98G1395

**SAPPHIRE TO WOOLGOOLGA PACIFIC HIGHWAY UPGRADE
PROPOSED AMENDMENTS TO THE CONDITION OF APPROVAL TO BIODIVERSITY
OFFSET & MITIGATION STRATEGY**

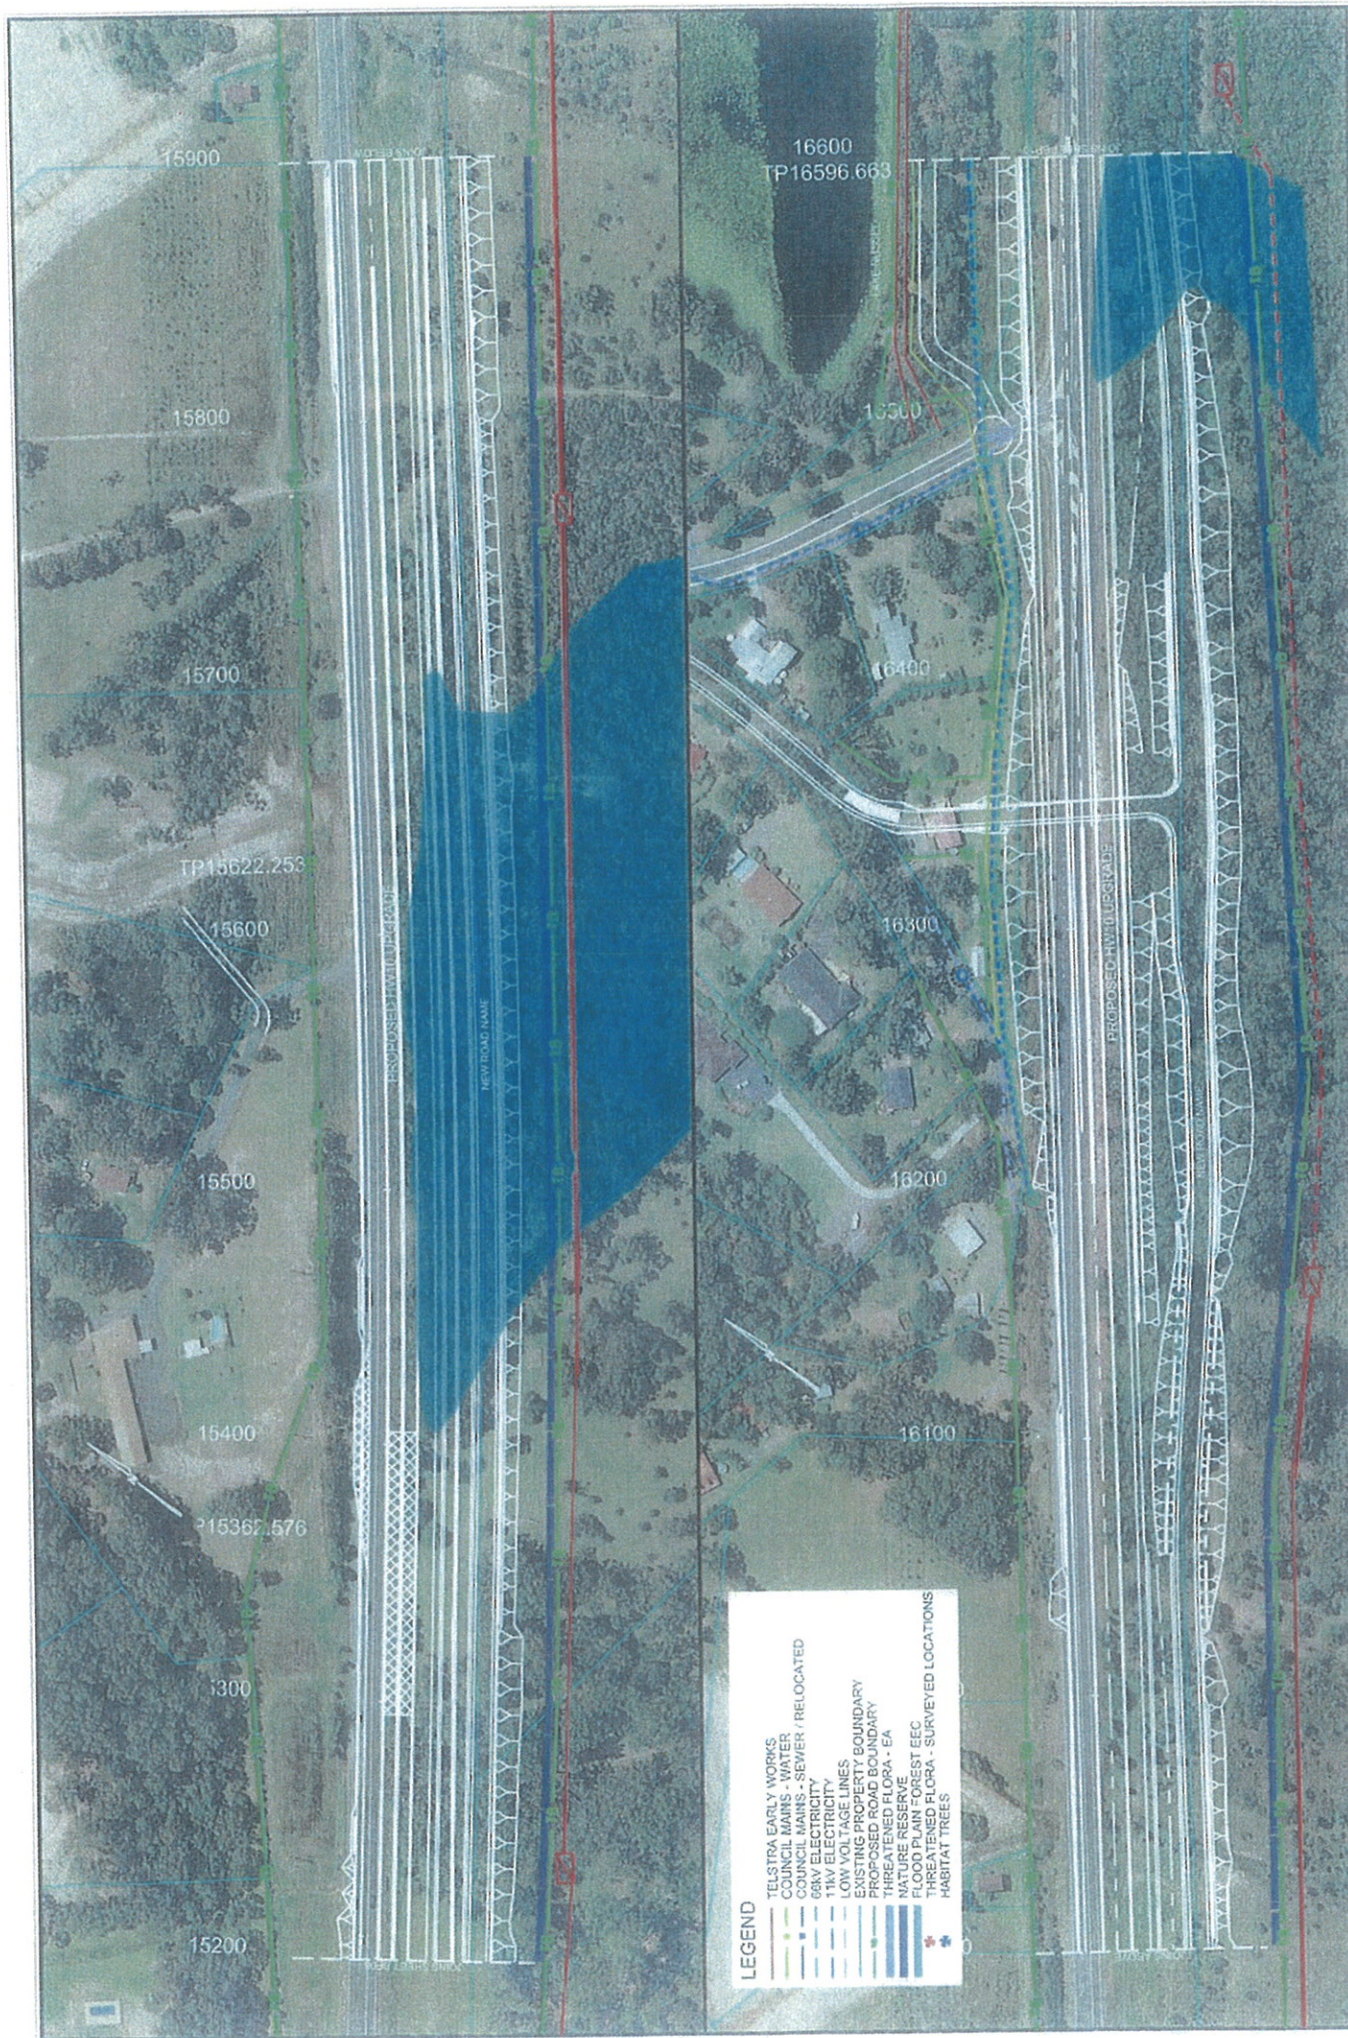
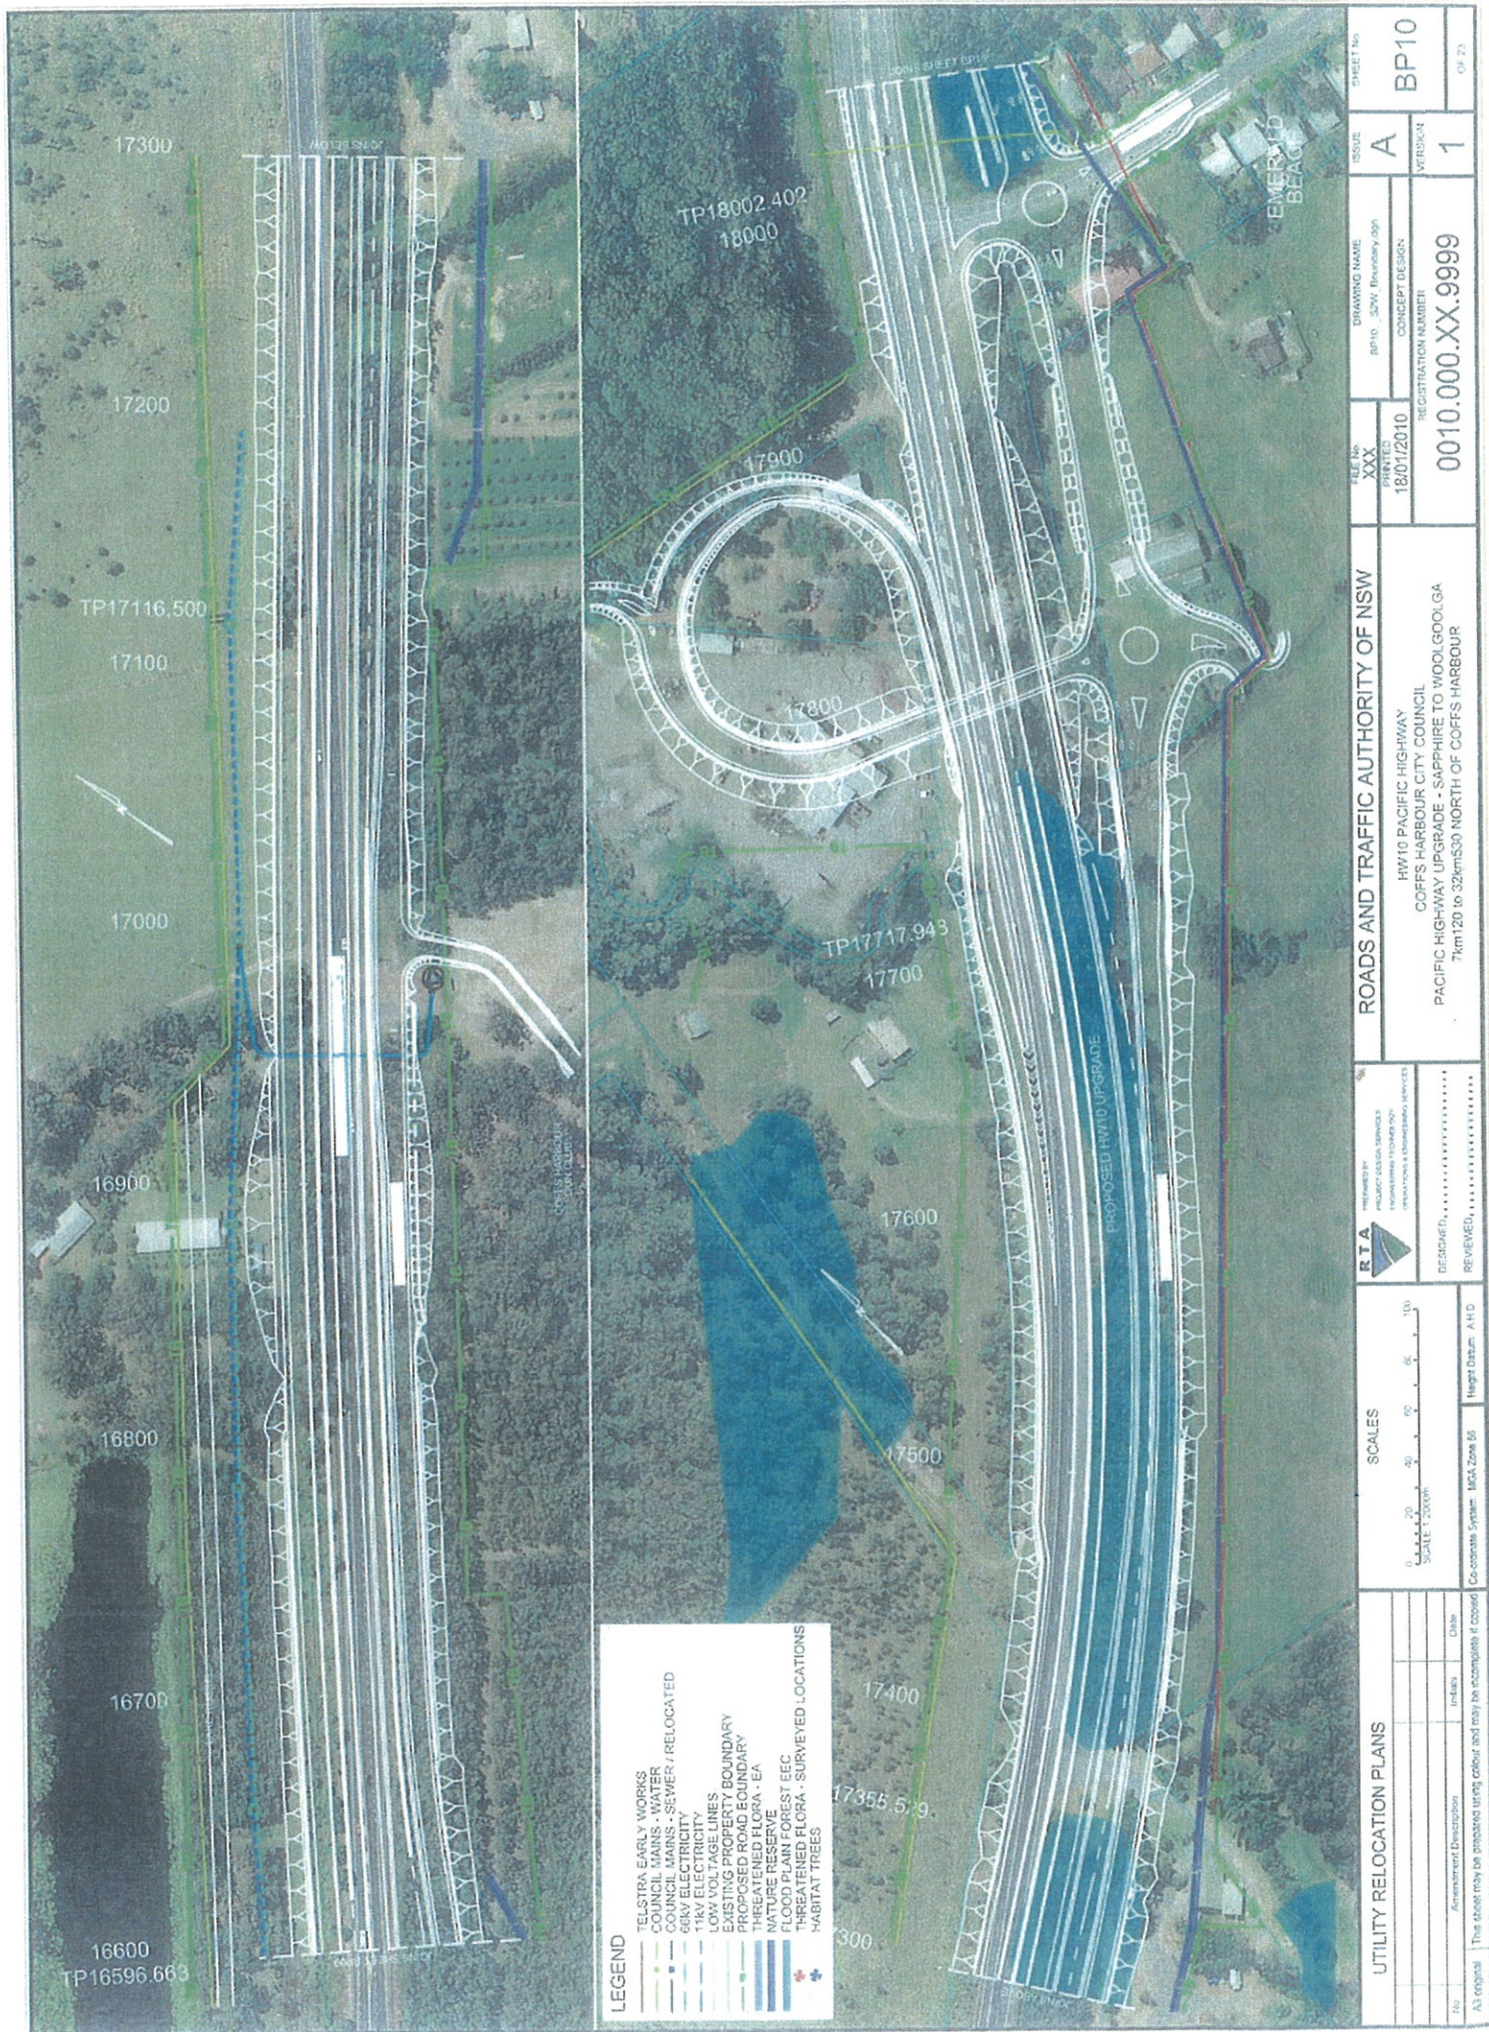
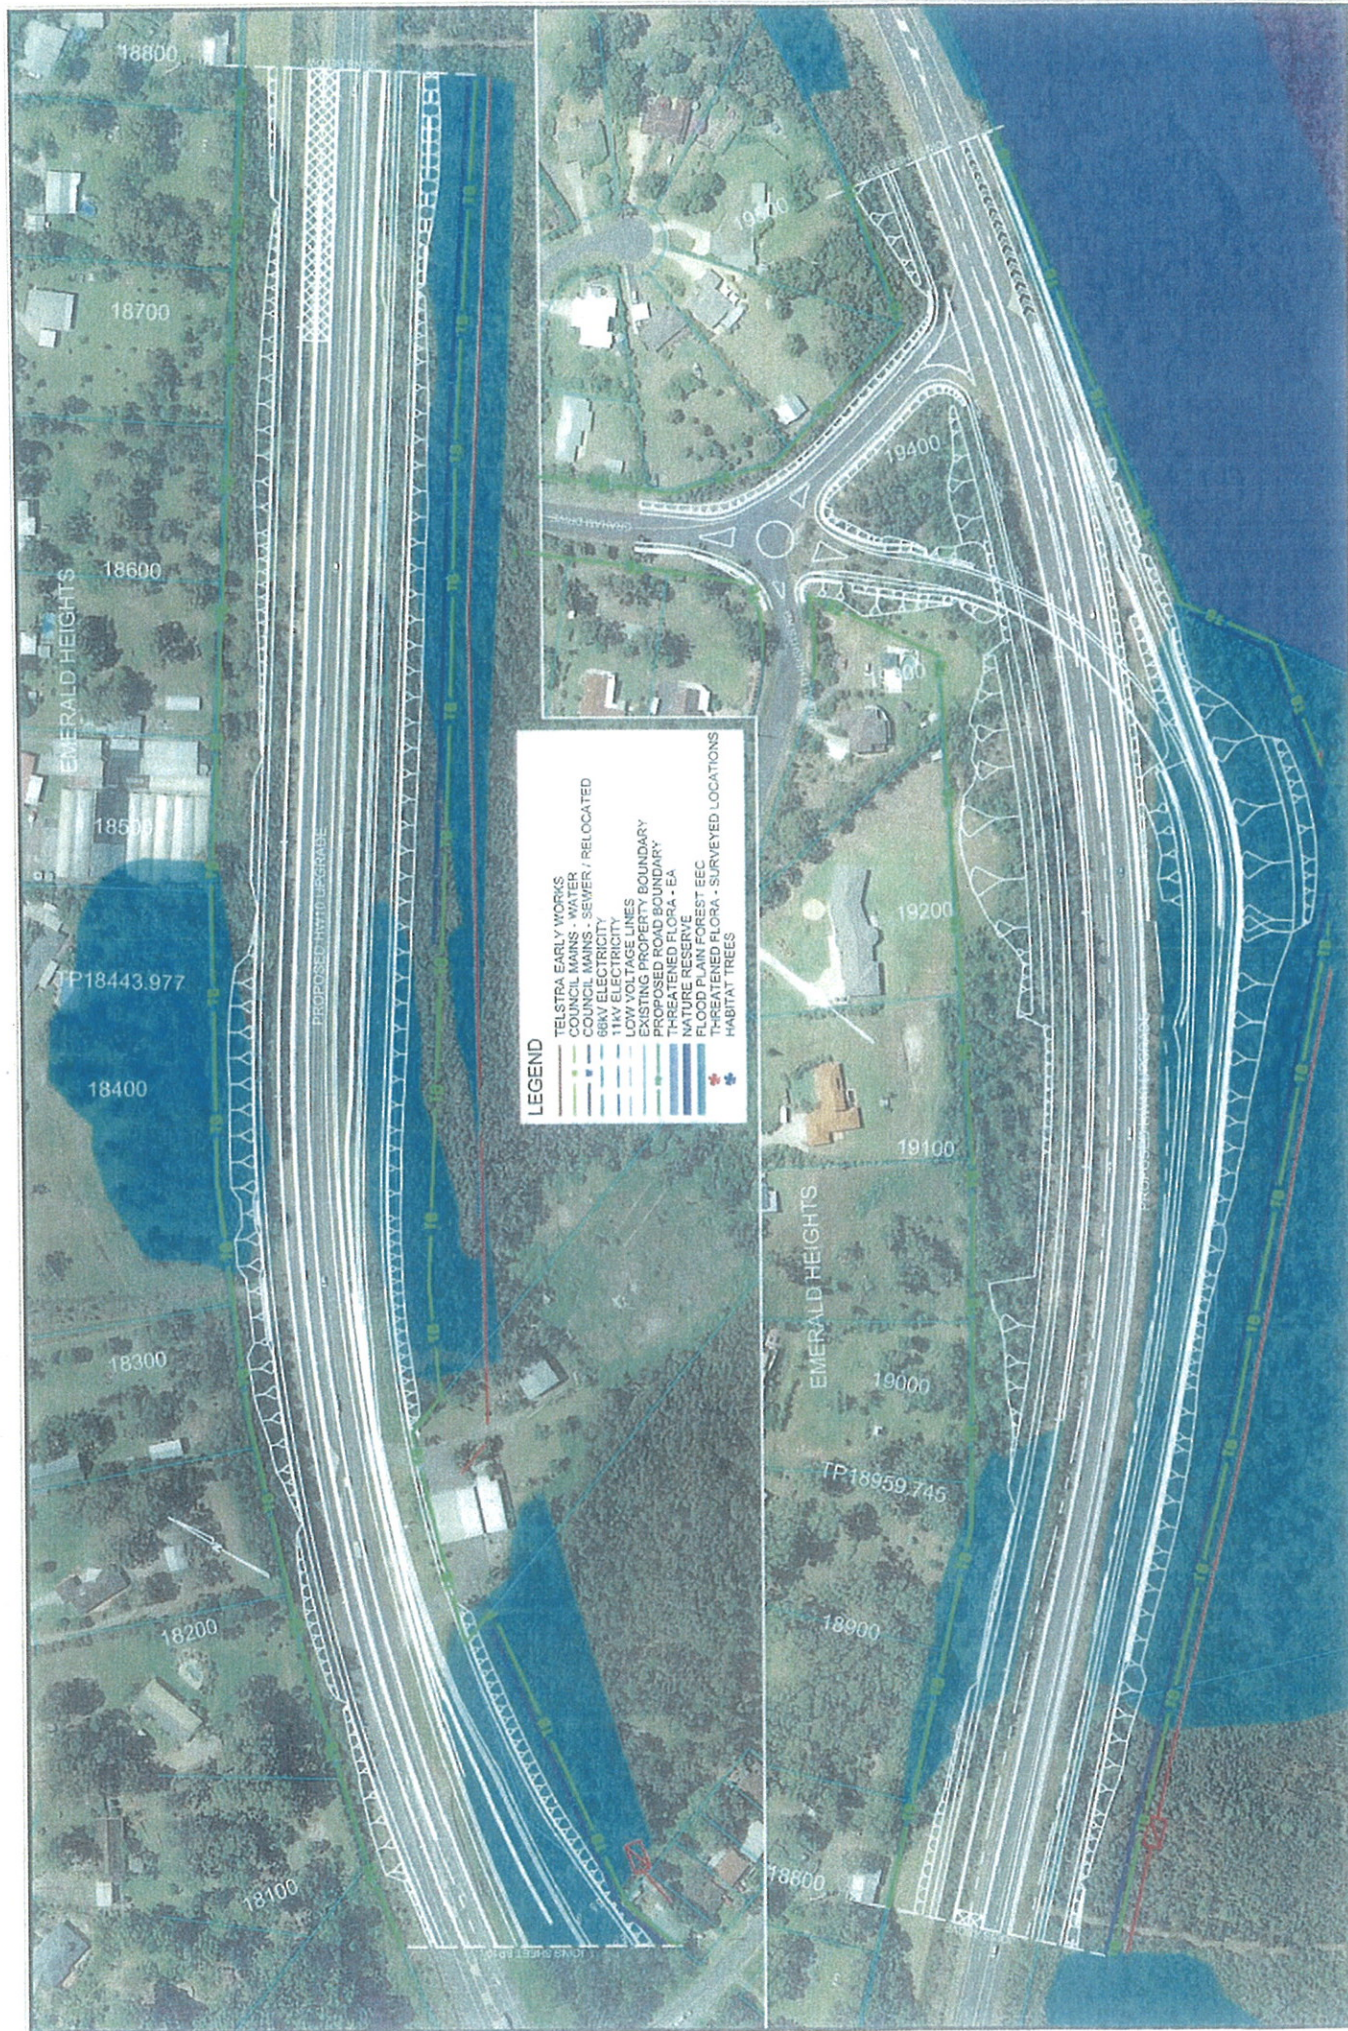
In view of the forthcoming discussions on developing offsets and to limit any impacts on the construction programme, the RTA is seeking an amendment to the condition of approval to allow the minor clearing of ECC. Specifically, it would enable the clearing of 1.44 hectares of ECC associated with the utility relocation works for Sapphire to Woolgoolga. DECCW has indicated in-principle support for this amendment and I understand has written to you separately in support of this approach. Details of the nature and extend of clearing in ECC are provided in Attachment A.

The utility relocations involve the clearing of a total 1.44 hectares of Coastal Floodplain Forest-Broad Leaved Paperbark an Endangered Ecological Community (EEC) listed under the NSW Threatened Species Conservation Act. The table below shows the breakdown of the clearing of EEC by utility relocation type.

Figures on BP09, BP10, BP11 and BP 22 below detail the location of the utility relocation works in relation the mapped EEC.

Mitigation Measures to reduce impacts of native vegetation, including EEC to be implemented via an Environmental Management Plan include:

- Where vegetation removal is required it is to be strictly controlled and clearing would be restricted to the minimum area required to undertake the works.

- The limits of vegetation clearing disturbance will be signposted clearly, delineated on site and recorded on work plans prior to clearing
- No service relocation works (including storage of plant, equipment, materials) or access by unauthorised personnel is permitted in native vegetation areas outside of the flagged works footprint.
